Project: 134-140 MARSDEN PLACE, PARRAMATTA
MACQUARIE PLACE

Report: BCA ASSESSMENT REPORT

Date: 23rd December 2010

Level 10 Floor Plan

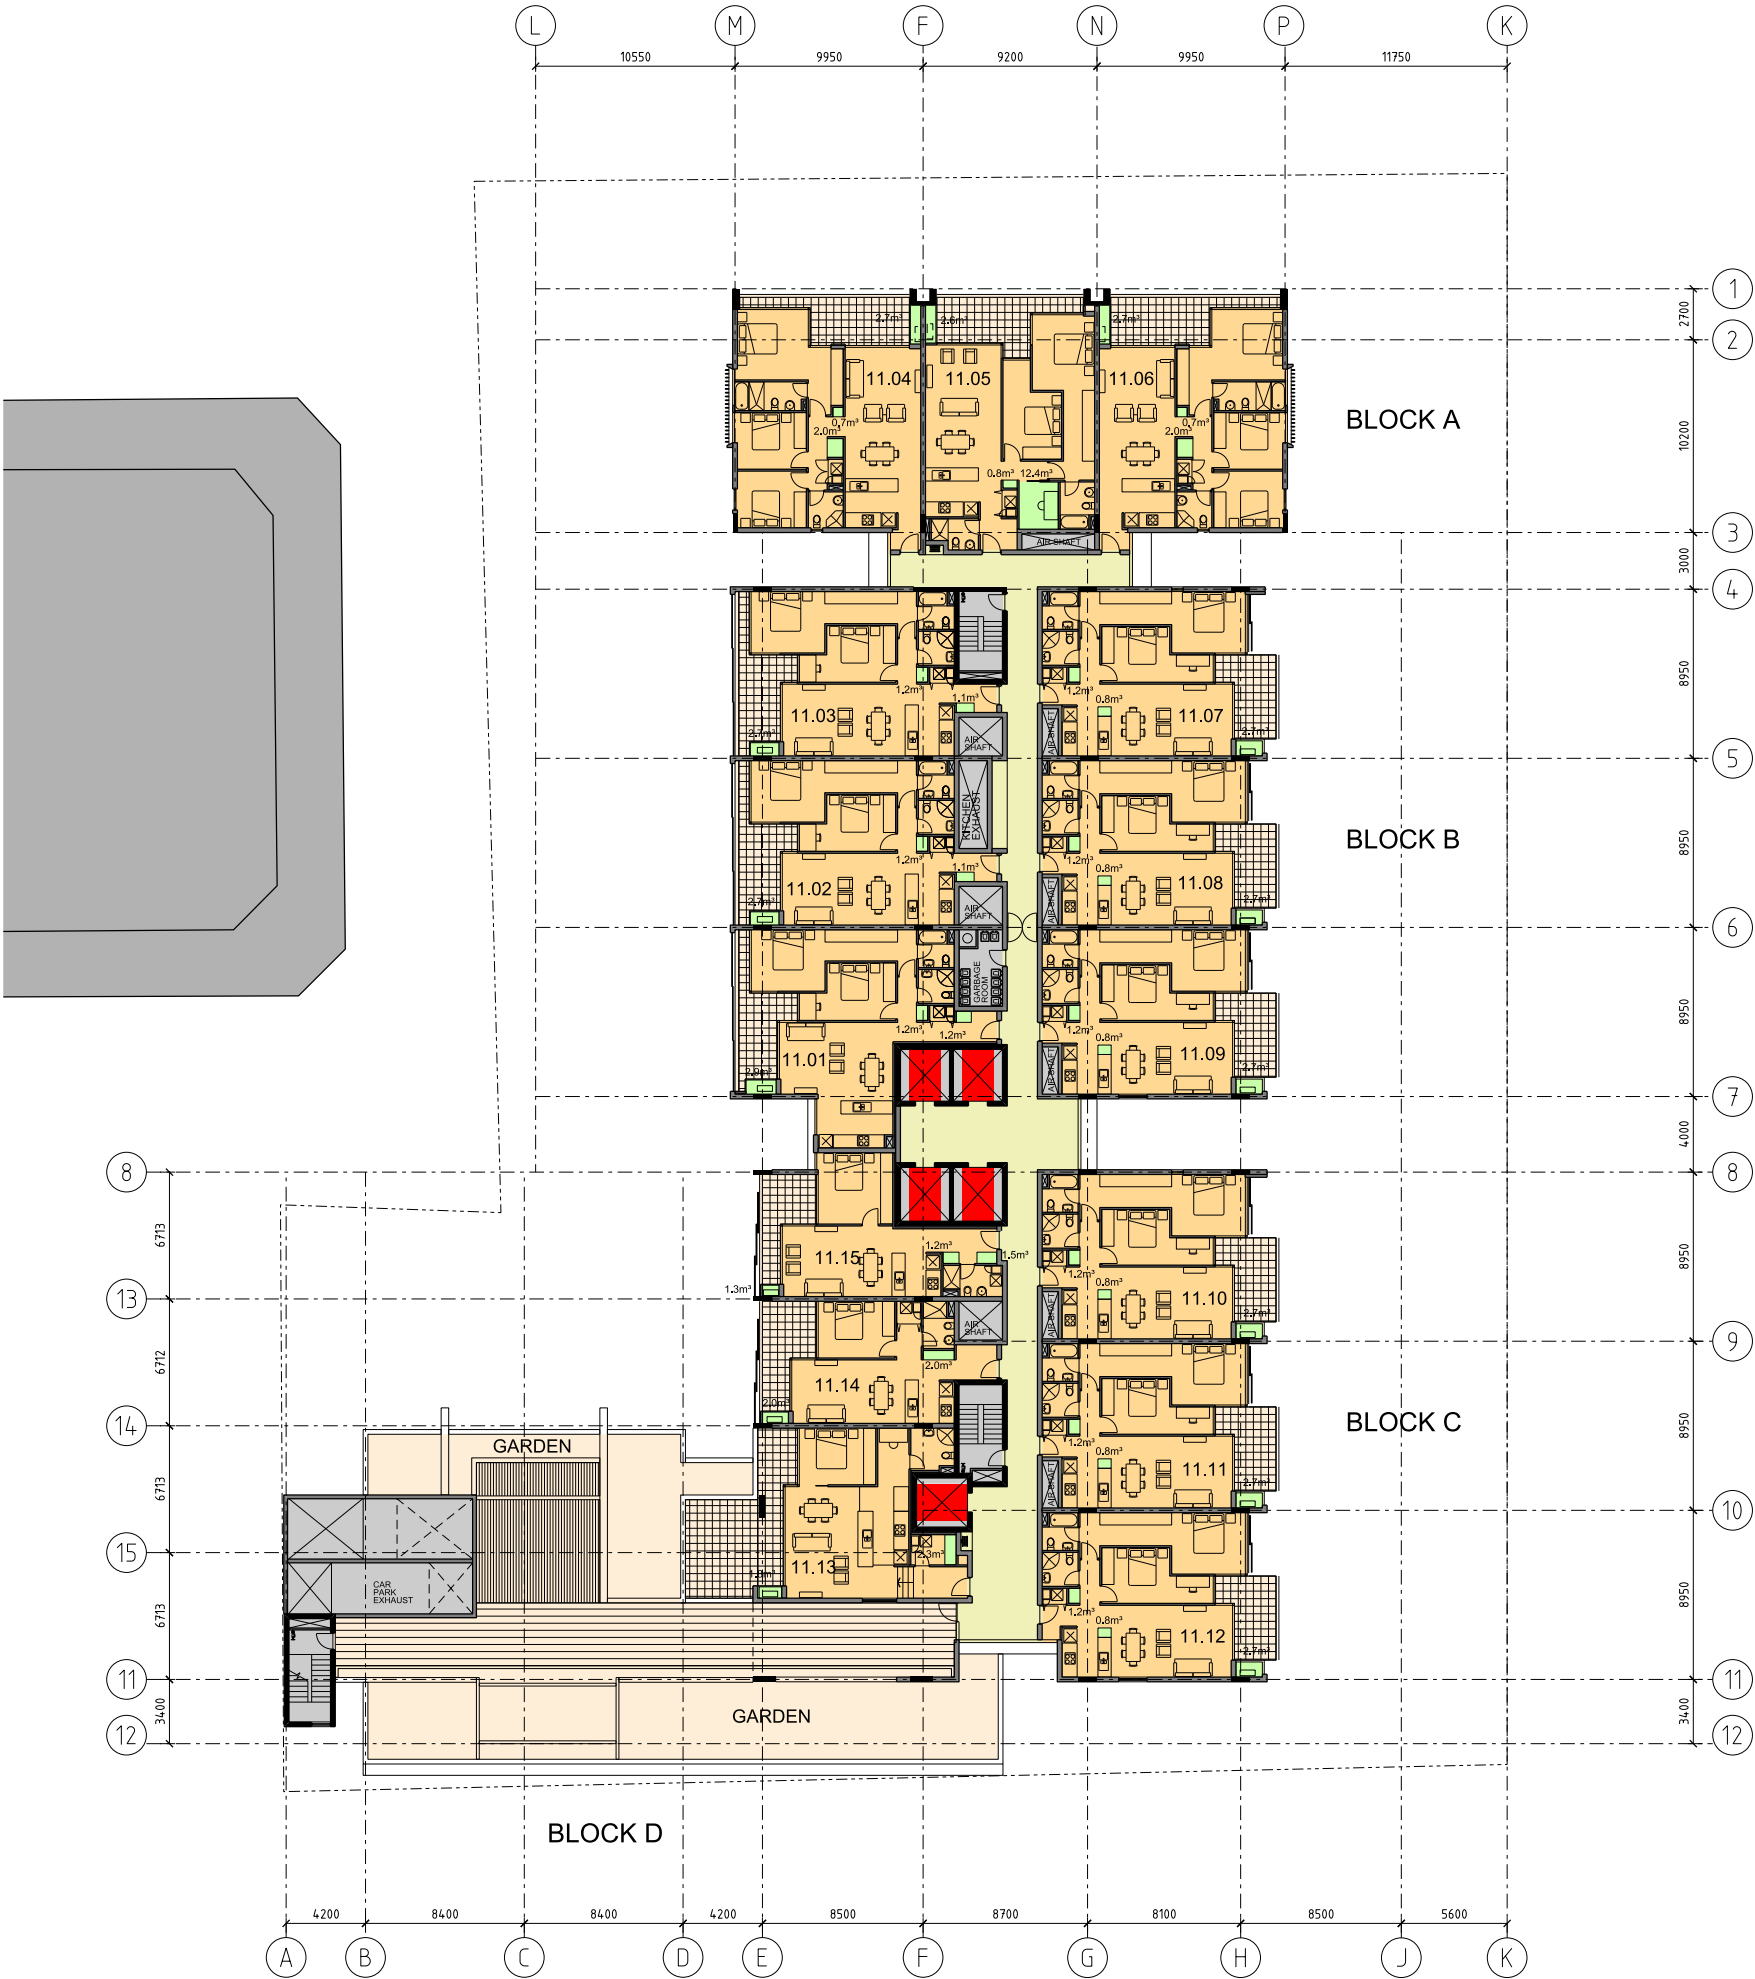
Residential units are required to be within 6m of an exit or a point of choice; a number of units, including Units 10.14, 10.15, 12.12, 13.12, 13.13, 21.11 and 21.12, are between 6 and 9m from an exit or point of choice. This increased travel distance is expected to be justifiable under an Alternate Solution at the CC stage.
